A417 Missing Link
TR010056

Statement of Common Ground with Coberley Parish Council

Regulation Number:	5(2)(q)
Planning Inspectorate Scheme Reference	TR010056
Application Document Reference	7.3.10
Author:	A417 Missing Link

Version	Date	Status of Version
C01	May 2022	Deadline 9

Drawing Title: **FIGURE 13.19 SCHEME HIGHWAY DRAINAGE - PLAN**

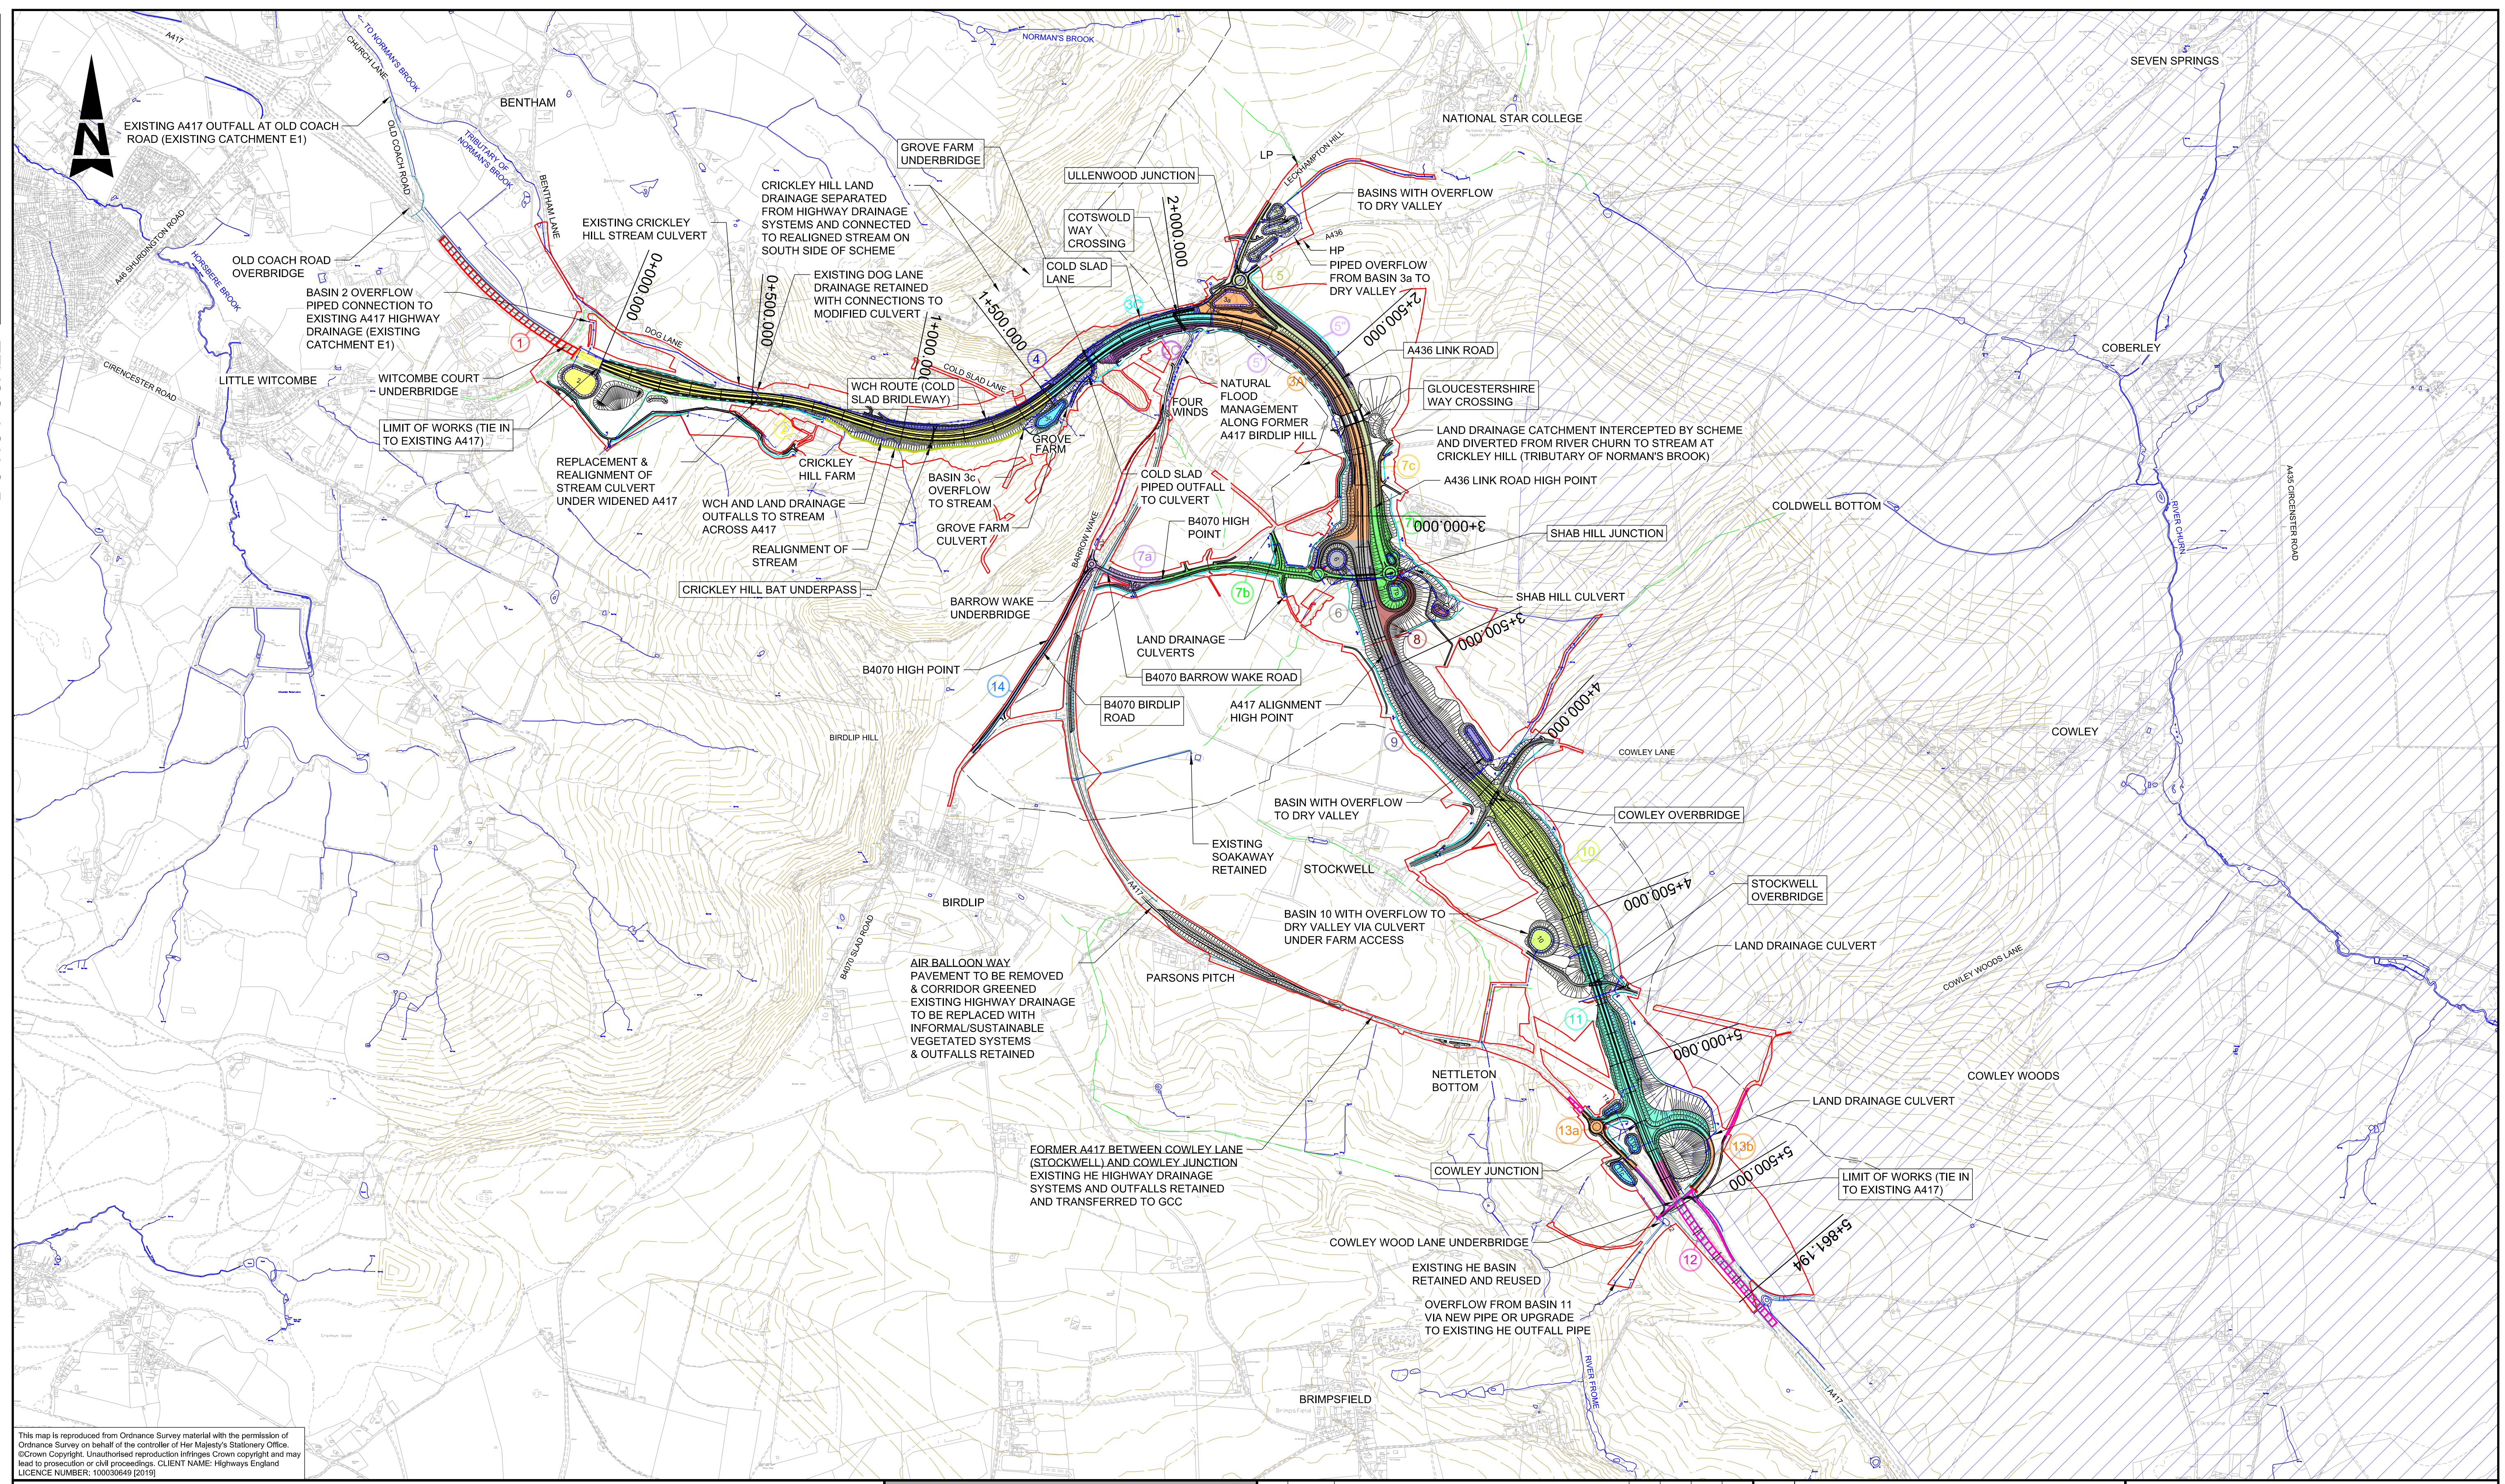
4.1	Attenuation around the Ullenwood Junction	<p>The Council have raised concerns regarding potential flooding near this new roundabout, due to water flowing down the new link road from the Shab Hill Junction, and seek confirmation required that these attenuation tanks will mitigate any such problems.</p> <p>The Council has also requested clarity on who will be responsible for the maintenance of the attenuation basins.</p> <p>The parish accepts, in principle, the information and assessments provided by National Highways – which is subject to their ongoing review of the information provided to date. It is their position that they remain concerned until such a time that the scheme is operational, and the assessment conclusions and relevant mitigations can be proved in a practical setting and further mitigated if and as required.</p>	<p>The highway drainage design would include basins to manage the quality and quantity of surface water run-off from the new roads.</p> <p>The basins will ensure no increase on surface water peak flows and volumes downstream and hence flood risk for events up to the 1:100-year return period with an allowance included for climate change.</p> <p>There are soakaways at the Cricket Club and the junction with Leckhampton Hill that serve the existing A417 Birdlip Hill and roundabout. These are known to exceed capacity during heavy rainfall and discharge dirty road run-off and silt to the adjacent land. The proposed scheme will address these existing capacity and contamination issues.</p> <p>National Highways can confirm that Gloucestershire County Council will be responsible for the maintenance of the attenuation basins, with details subject to a separate agreement.</p>	Meeting, 28 February 2022
